CITY OF ALBUQUERQUE

**Re: Starbuck's
1000 Rio Grande NW
Request Permanent C.O. - Accepted
Engineer's Stamp dated: 6-17-16 (H13D021)
Certification dated: 9-7-16**

**Re: Starbuck's
1000 Rio Grande NW
Request 30-Day Temporary C.O. - Accepted
Engineer's Stamp dated: 6-17-15 (H13D021)
Certification dated: 3-24-16**

**RE: Starbucks and Burger King, Tract 338-B, 1000 Rio Grande Blvd. SE
Grading and Drainage Plan
Engineer's Stamp Date 6-17-2015 (File: H13-D021)**

Drawing file: FINAL / H13D021_BP_Cmmt2.pdf

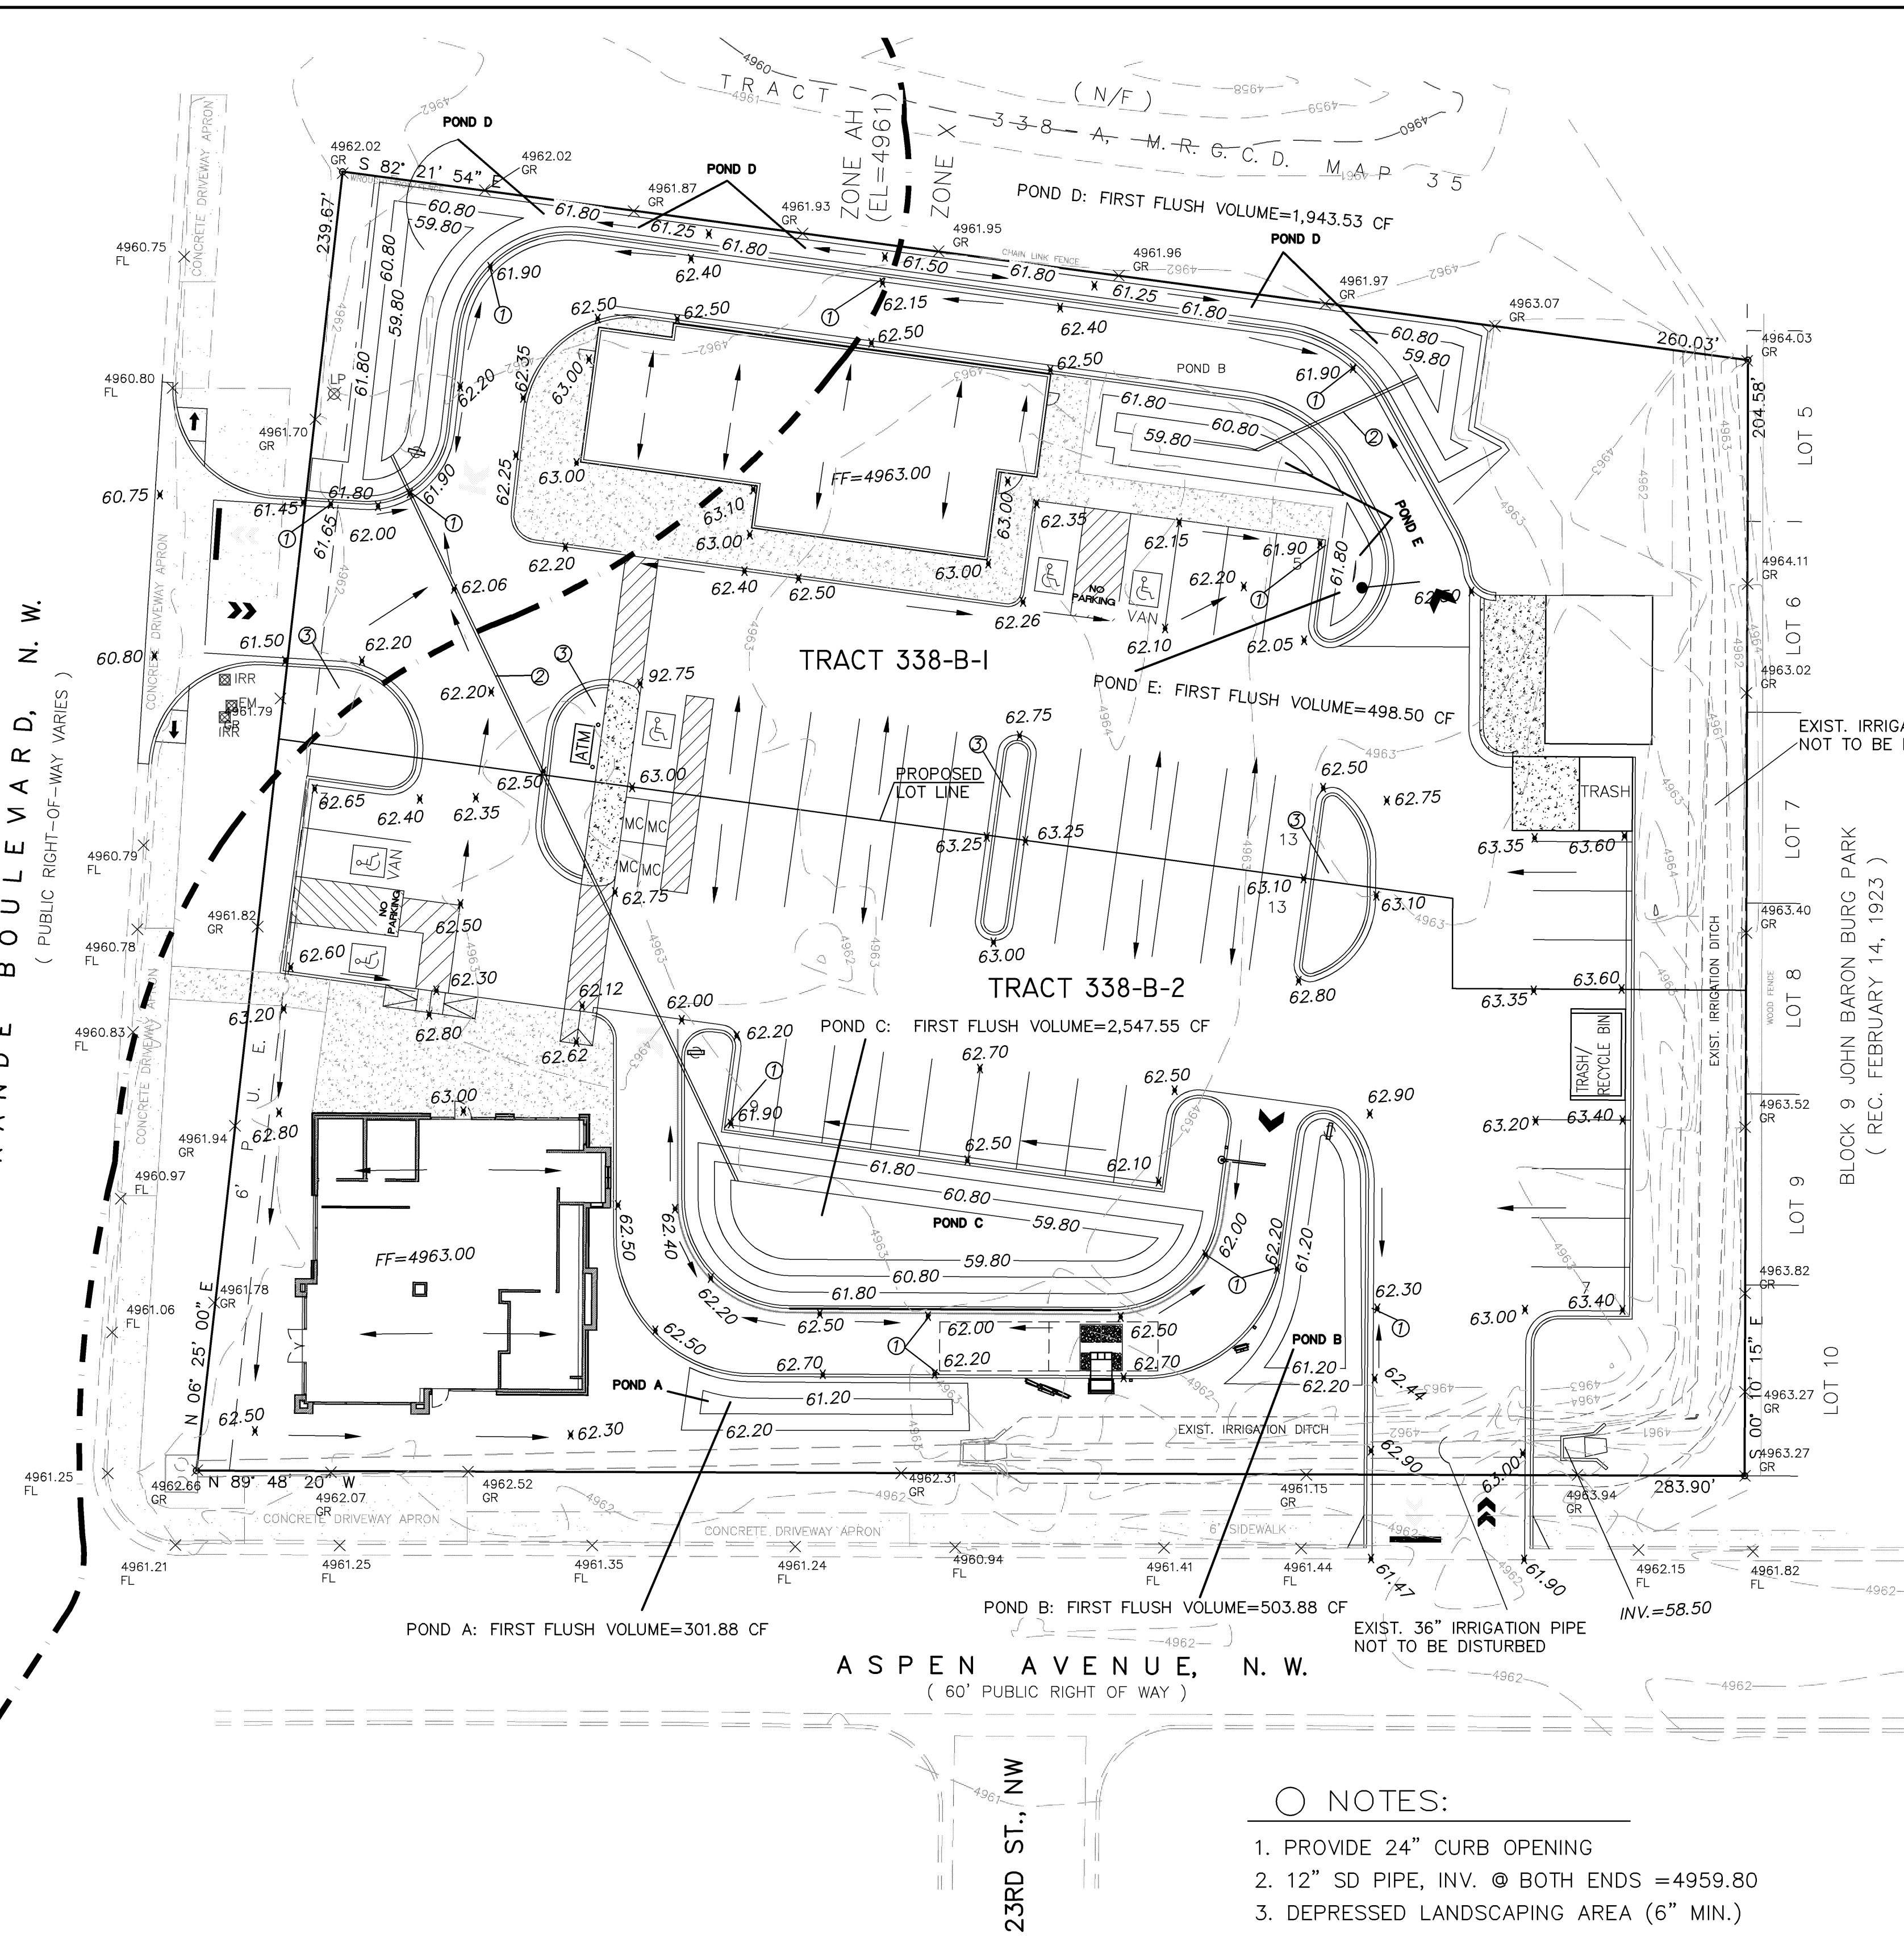
- 4-6-15 Reza Afaghpour
- 1) If the curb cut at the accessway is allowing discharge from Pond D, label the swale from this pond to the 61.65 elevation, delineating a clear path for stormwater to spill from the pond.

- 2) Provide a small section of riprap downstream of the curb cut within the swale at the north boundary of the site (Elevation 62.15) where flow is being collected from the north building in order to prevent site erosion near the property boundary. *OK*

- 3) Text for "Irrigation Pipe not to be Disturbed" is cut off on the right side of the plan view.
 - 4) The 92.75 elevation shown within the parking lot at the corner of one of the handicapped parking spaces is in error. I think it was meant to put "62.75"?

- 5) Provide a grease trap to collect storm drainage from the trash dumpster area.
 - 6) Make sure that the write-up matches what is shown on the plan view. The write-up is still referencing 6" pipes instead of 12" pipes, and it is still showing that inlets are collecting flow where there are none.

Drawing file: FINAL / H13D021_CO_Temp_30Day_Starbucks.pdf

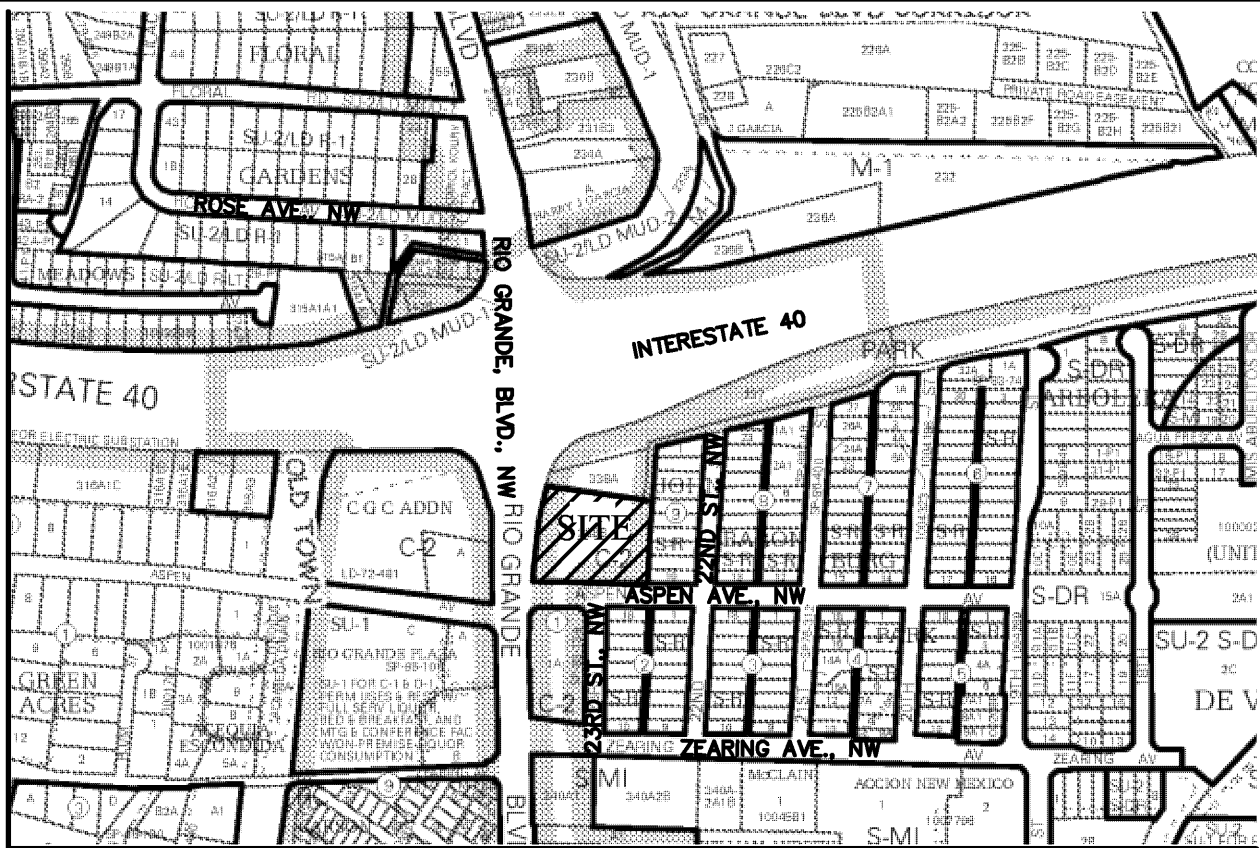
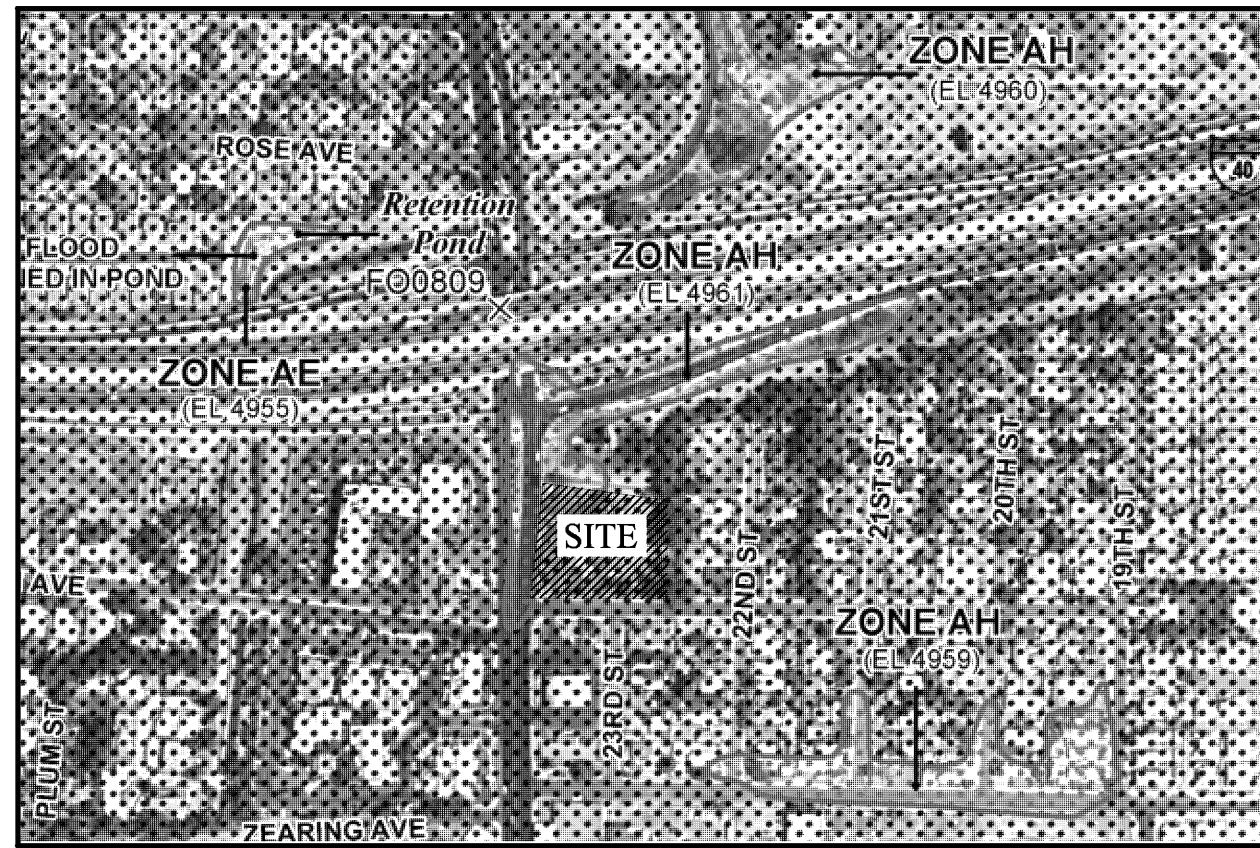
- The sidewalk on the south side of the building was not as-built on the drawings. Sidewalk is blocking flows to pond. Provide pipe underneath or sidewalk culvert.
- Transformer is on a mound that is diverting flows to the south and not into pond 'A'. A landscape water valve box is blocking flows into pond 'A'.
